COMMUNITY MEETING REPORT FOR REZONING PETITION NO. 2020-166

Petitioner: C4 Investments, LLC
Rezoning Petition No.: 2020-166
Property: ± 8.73 acres generally located at 6230 Statesville Road (the "Site").

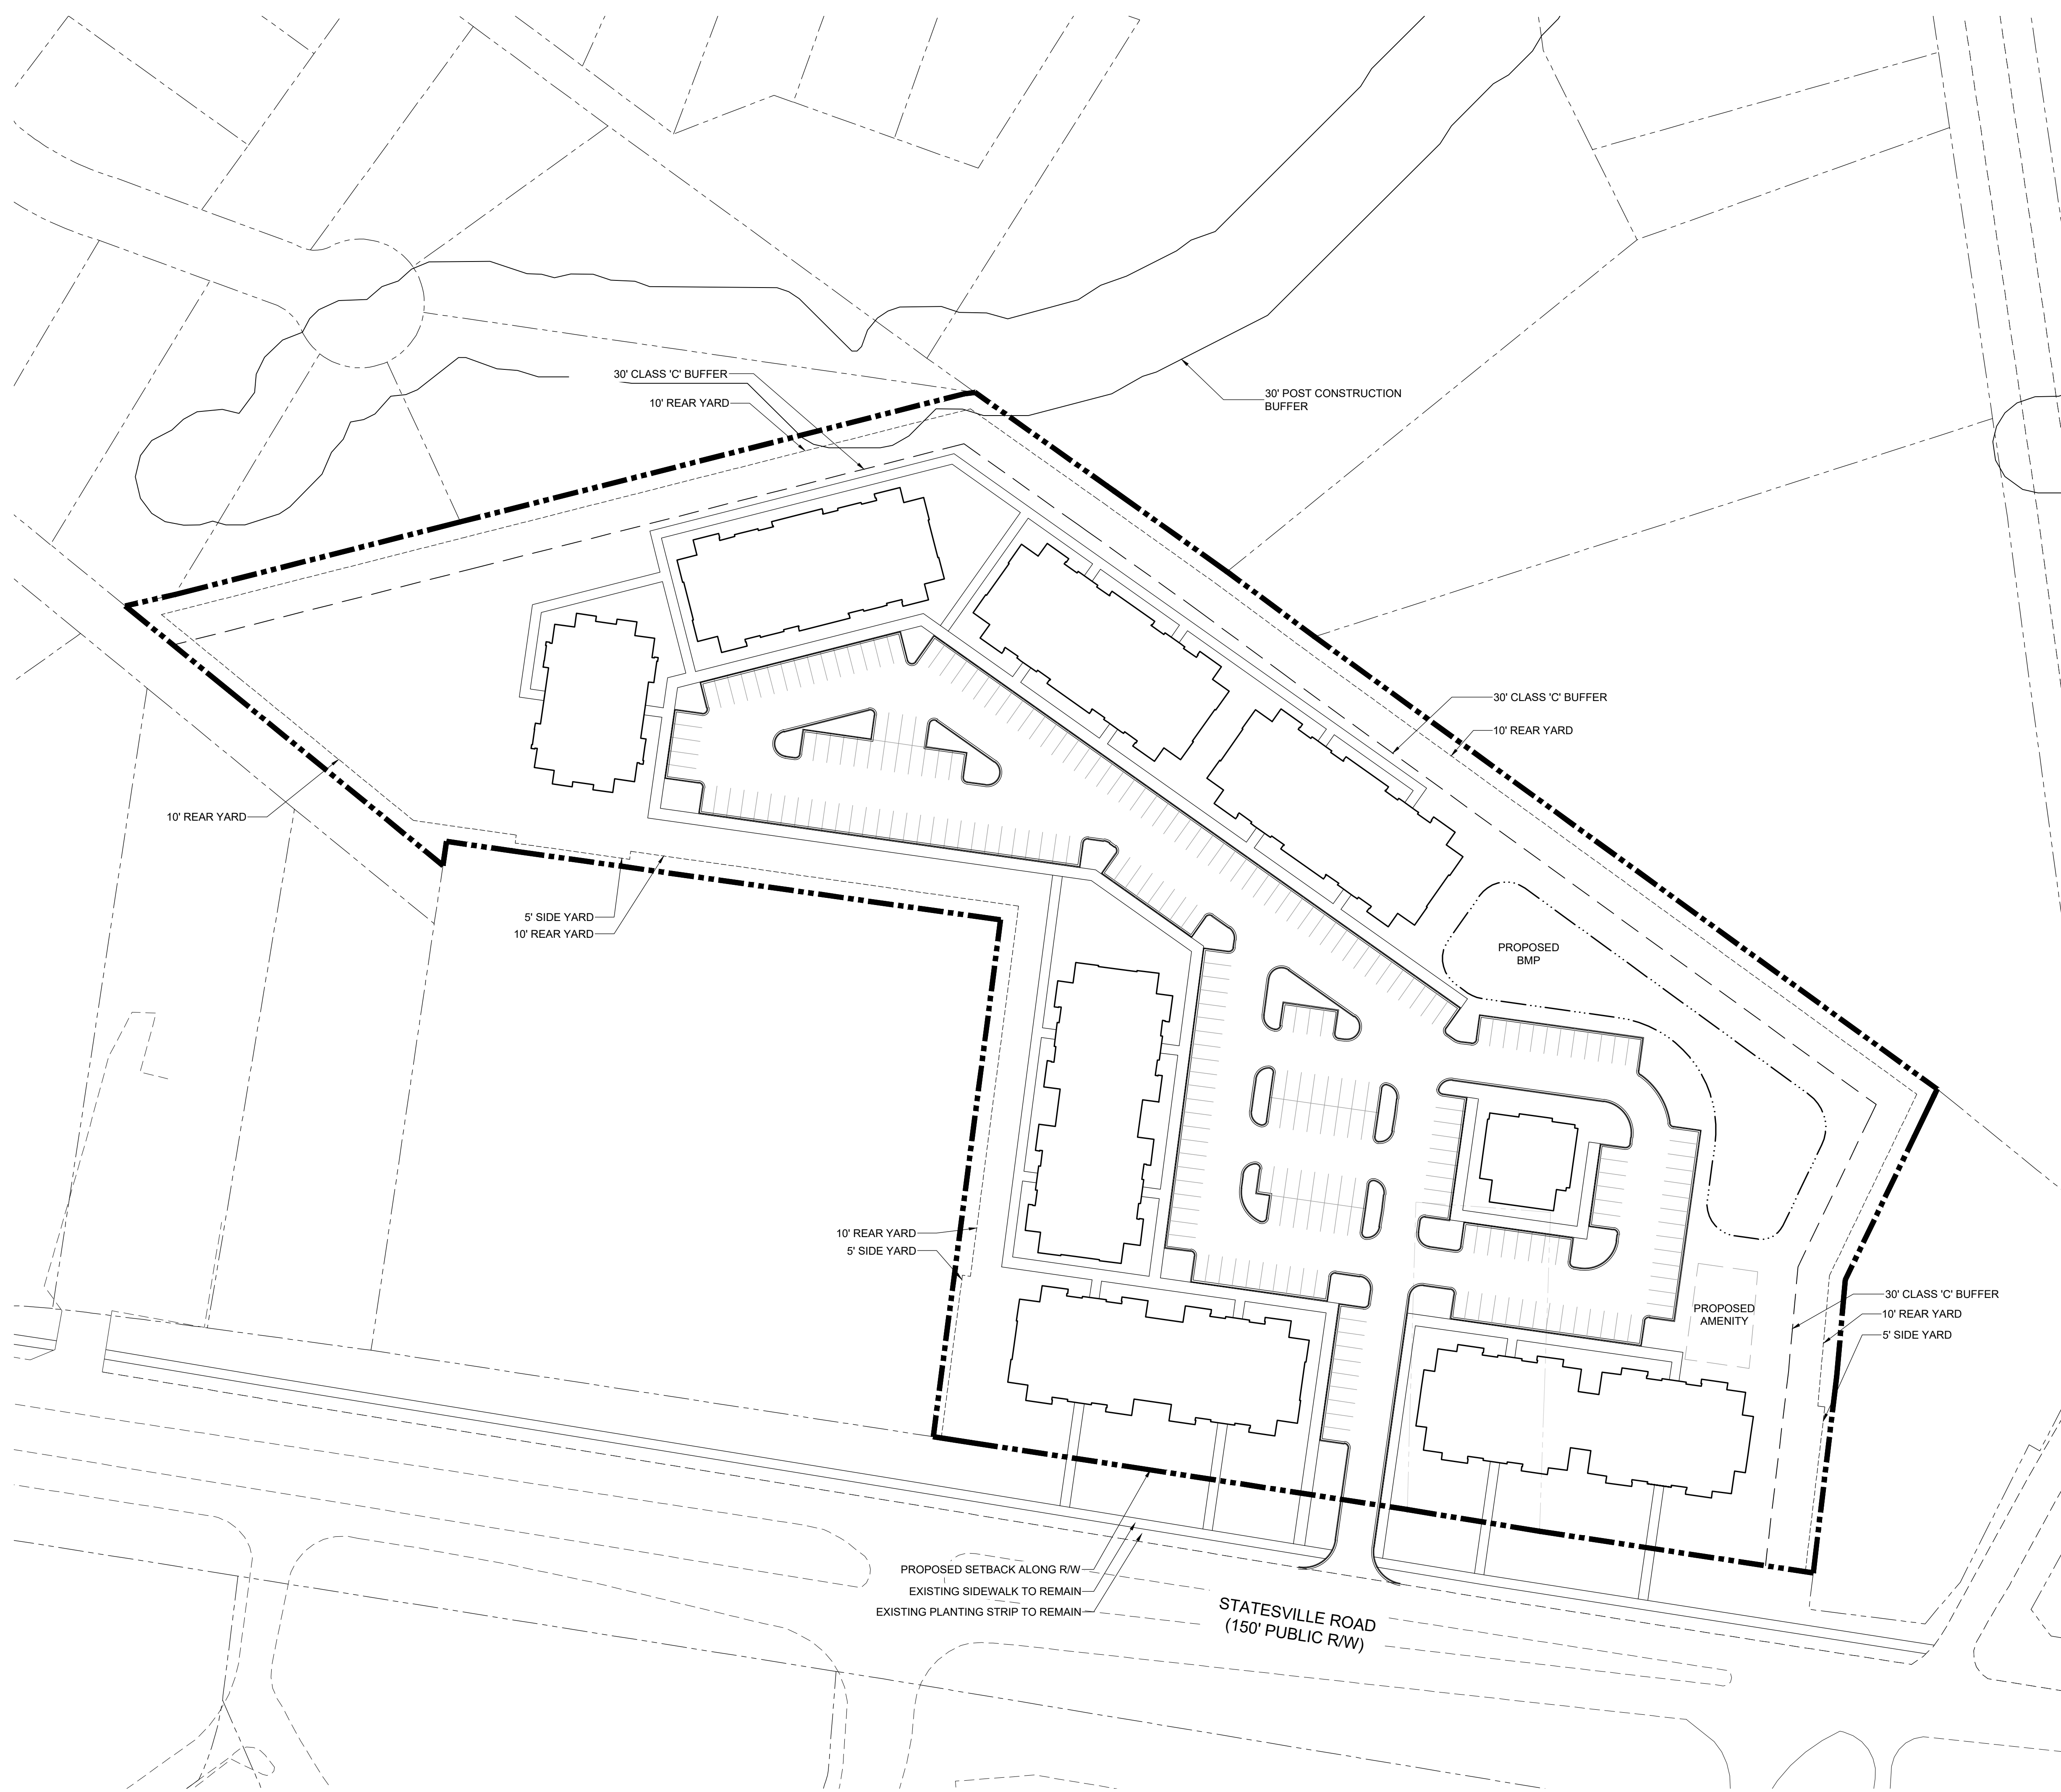
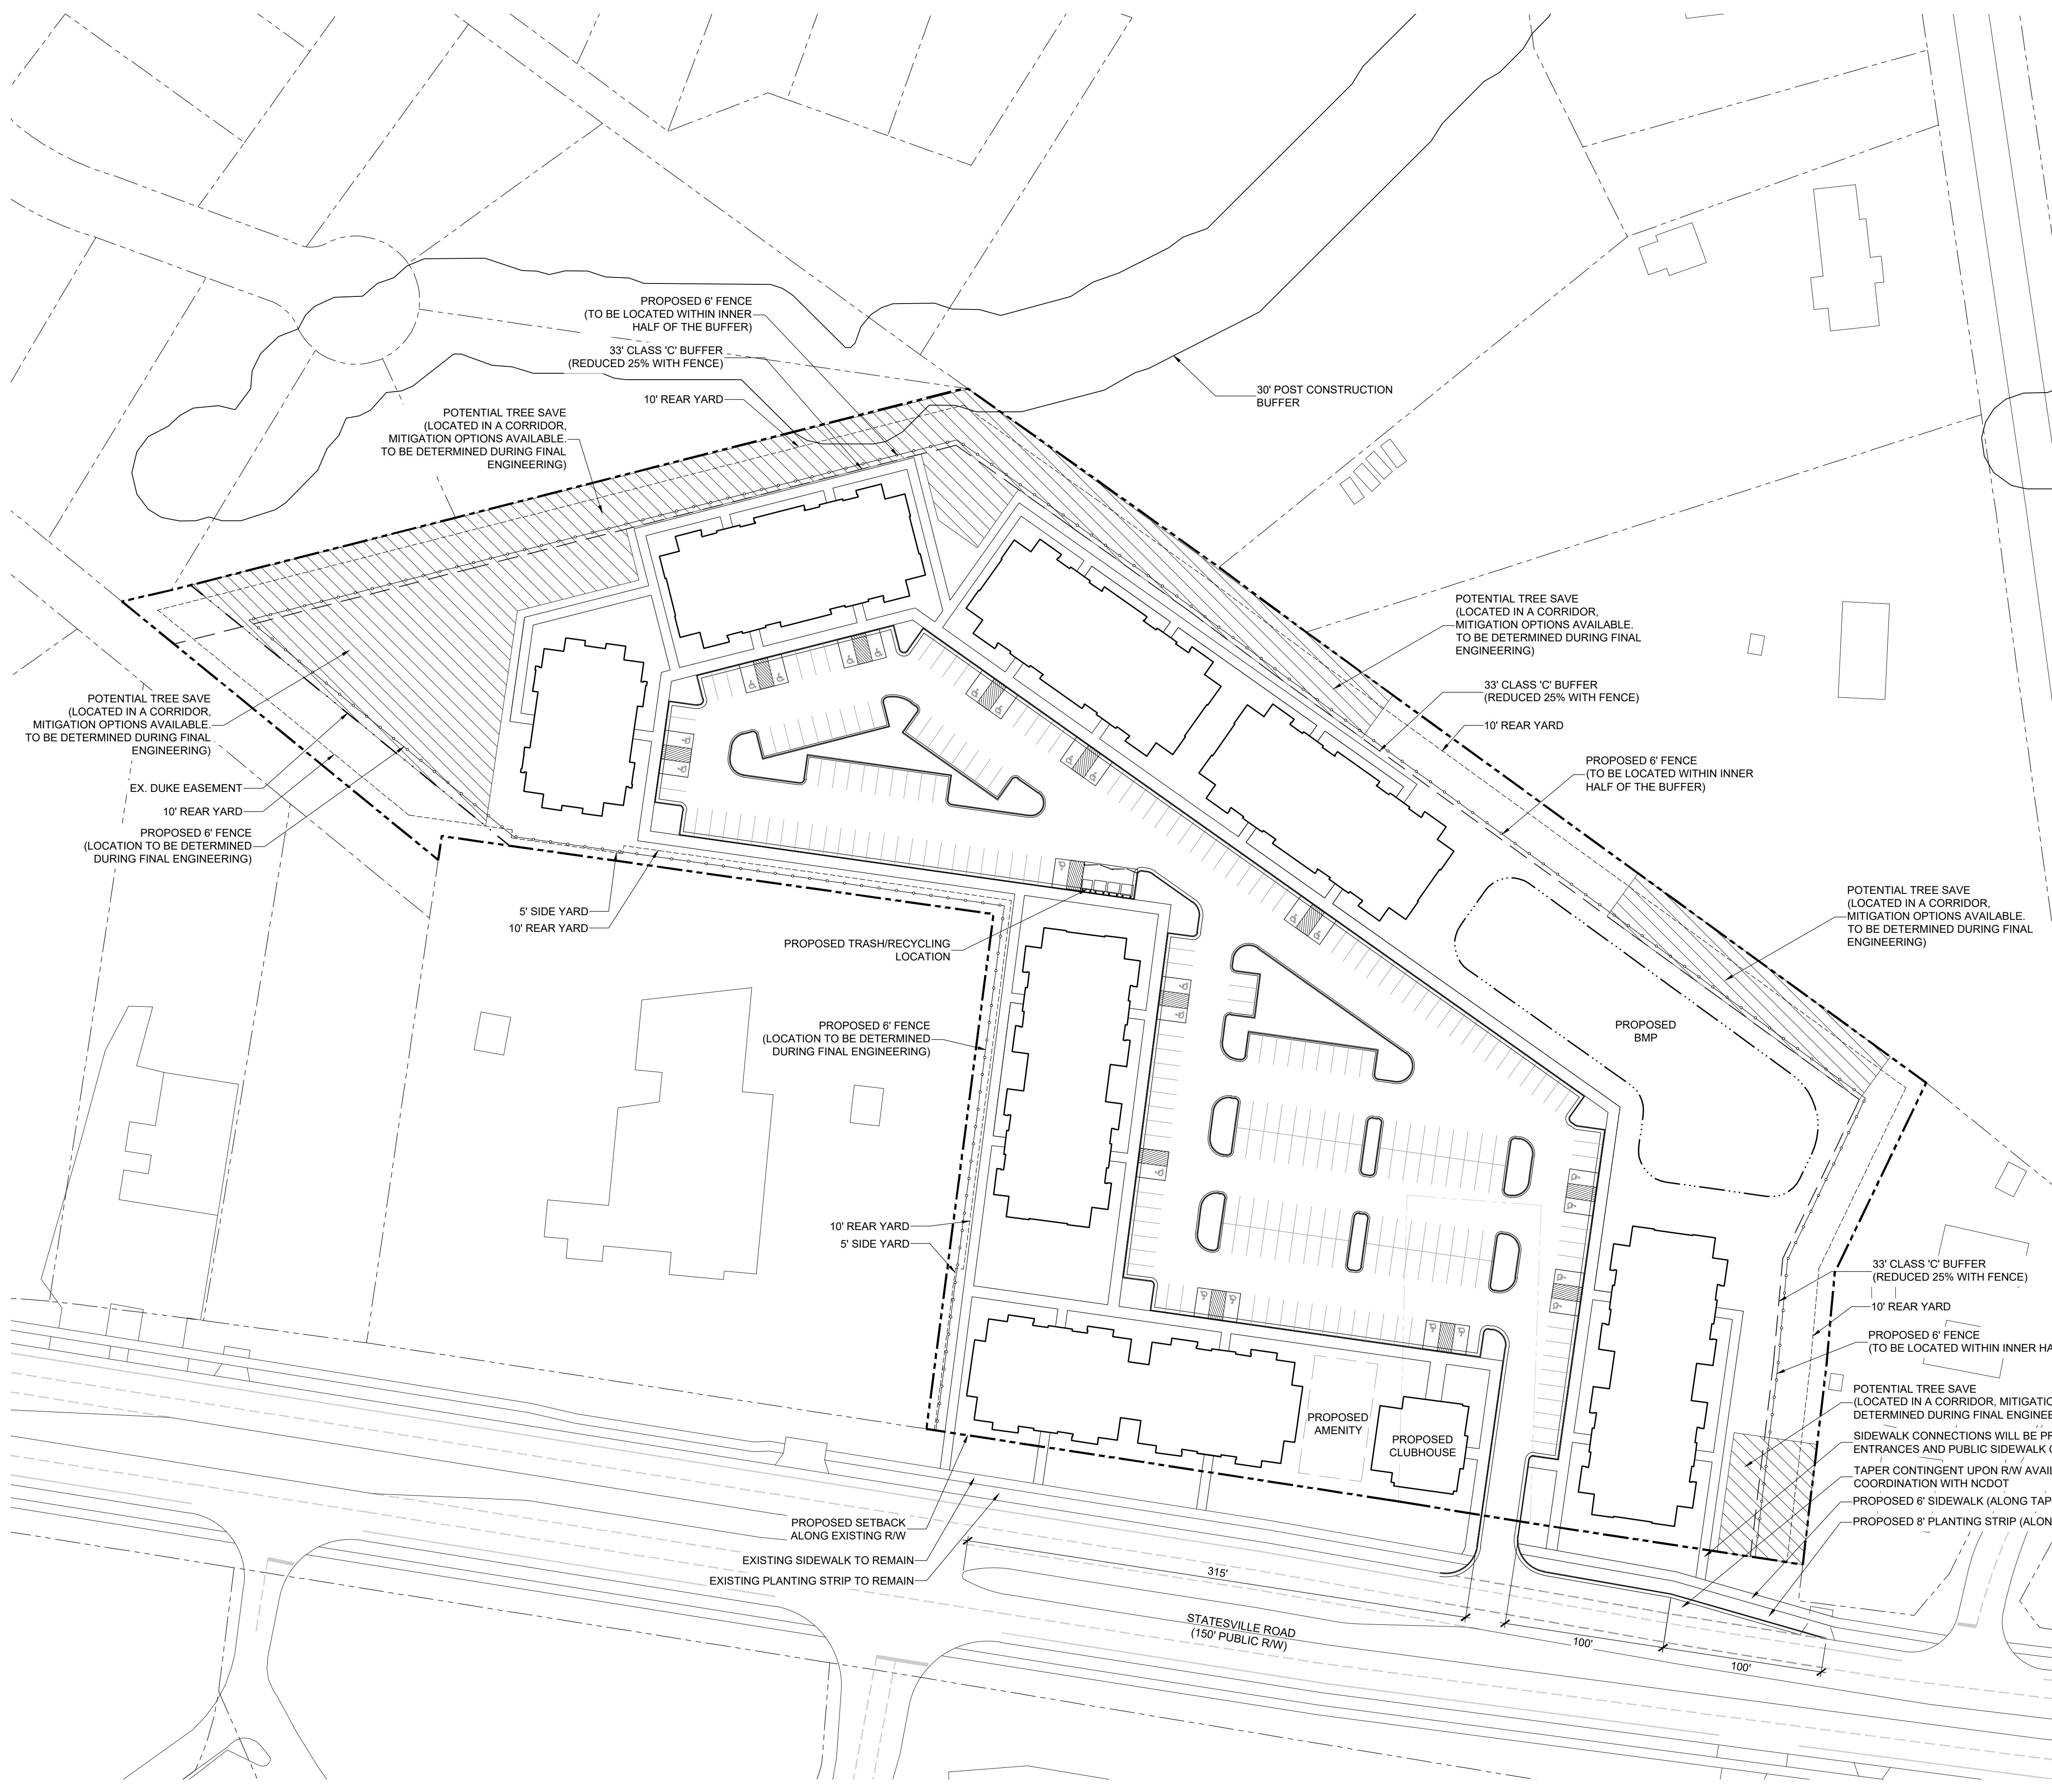
Adjacent property owners inquired about the addition of a fence to mitigate walk-through traffic. Mr. Sittema was not aware of the current foot traffic and committed to explore fence and buffer options.

Attendees asked about buffers and site drainage. The proposed 30-foot buffer will be a combination of new and existing trees. The existing berm level has not been studied but will be as the site develops. The detention area is proposed for the lowest point of the site to mitigate current and future run off.

The Petitioner will continue to work with the adjacent property owners and explore options to install a fence in combination with the buffer plantings.
